# CITY OF ALBUQUERQUE

**RE: Lots 16 Block 4 Volcano Cliffs Unit 22 SAD 228  
6427 Canavio Pl. NW.  
Grading and Drainage Plan  
Engineers Stamp Date; 12/2/2021 (D10D003D16)  
Pad Certification Date; 2/24/2022  
CO Certification Date; 9/28/2022**

Shahab Biazar, P.E.  
City Engineer,  
Development Review Services

HASLAM, VINCENT (CANDELARIA HOMES) - G & D PLAN

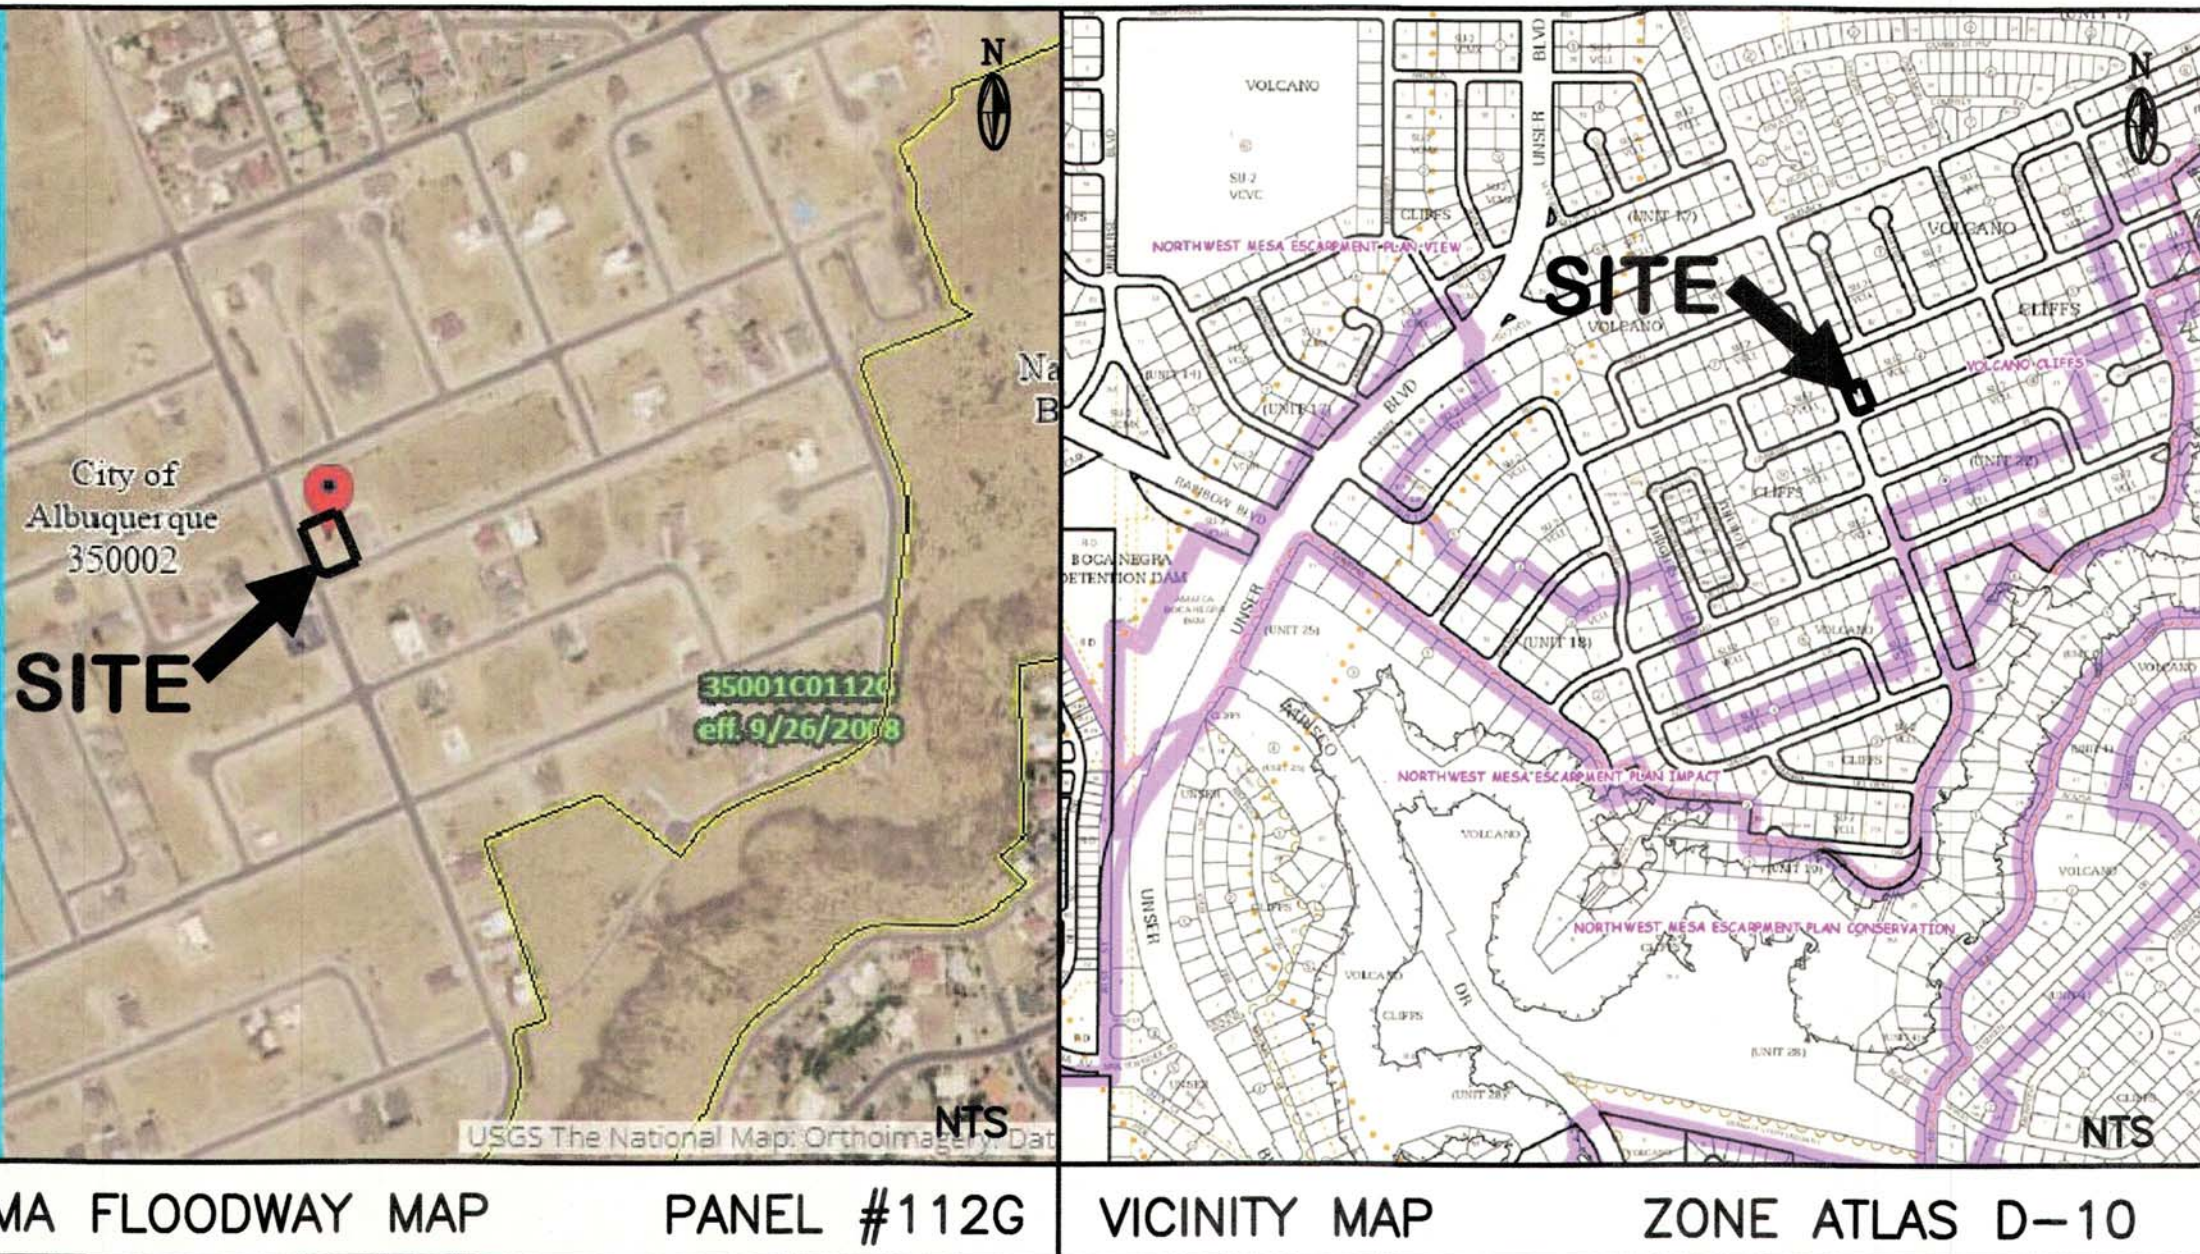
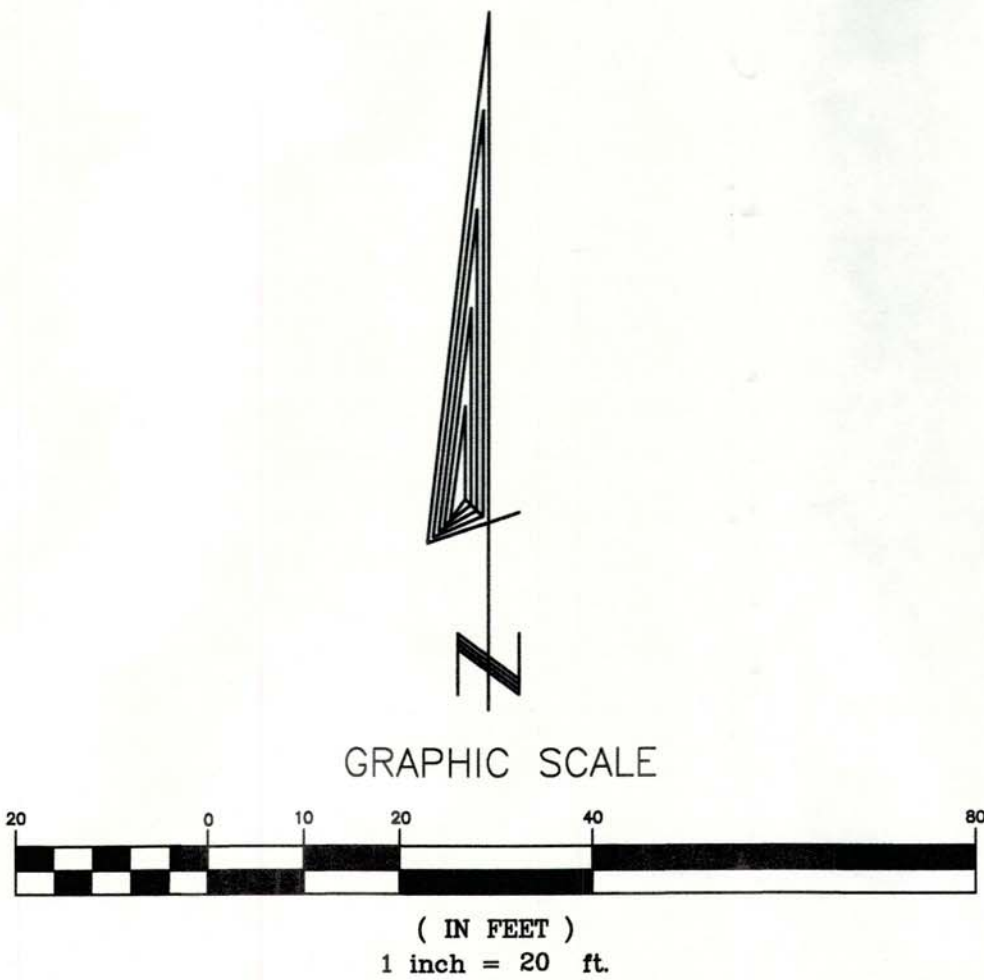
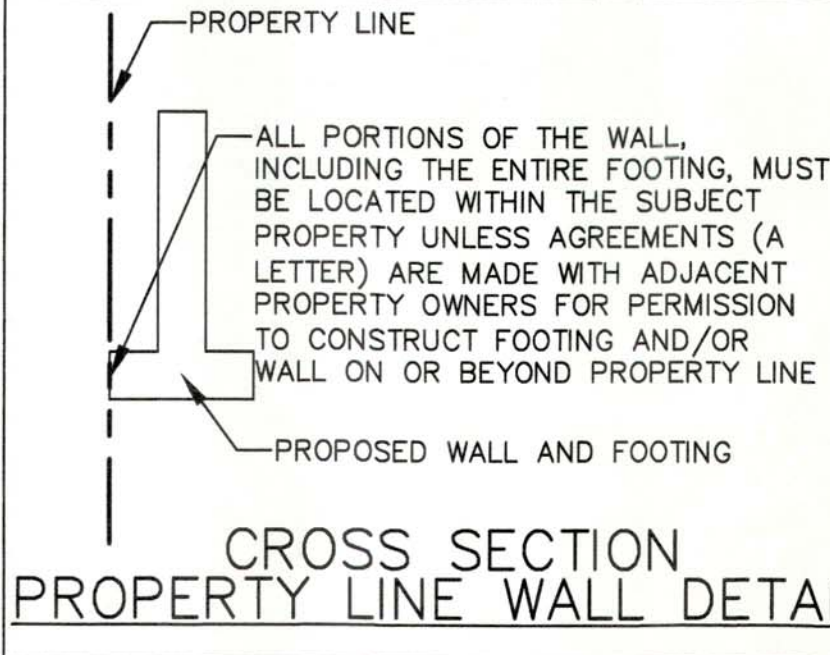
- All construction material in and around the home needs to be removed including the port-a-potty.
- Block wall being placed from property line to home south side needs to have a turn block to allow for flows to exit to the front yard. If this is not the case, flows need to be shown as being retained in the rear yard and if pond has sufficient capacity.
